Our ref: HA/2019/121264/02-L01
Your ref: M/25/19/PL
Date: 03 September 2019

Amended docs- revised FRA. Replacement dwelling

27 Central Drive, Elmer, PO22 7TT

Environment Agency Position

Proposed Floor Plans

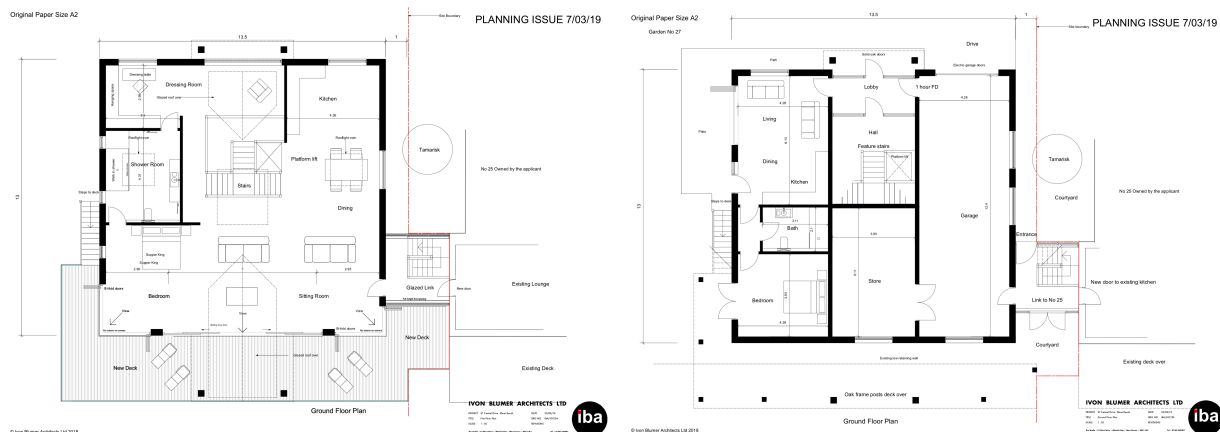
The proposed replacement dwelling is located in flood zone 3 and is at high risk of tidal flooding. Resubmission of the flood risk assessment shows that the finished floor levels of the ground floor shall be set at 4.41mAOD, which is higher than existing (4.11mAOD) but would still be at risk to flooding as future flood levels are 5.00mAOD, meaning the ground floor could be susceptible to 590mm flood depths during the lifetime of the development.

Although primary living accommodation will be located on the first floor (set at 7.00mAOD), there will still be a bedroom on the ground floor. Due to the level of risk this would usually lead to an objection. However as previous dwelling was a bungalow, this development would be providing a betterment as occupants will now have safe refuge on the first floor.

- Finished floor levels shall be set no lower than 4.41m above Ordnance Datum (AOD)
- Mitigation measures shall be incorporated including construction materials of the first 600mm of the ground floor that are capable of withstanding the potential risk of flooding and the use of floodgate systems of all door openings
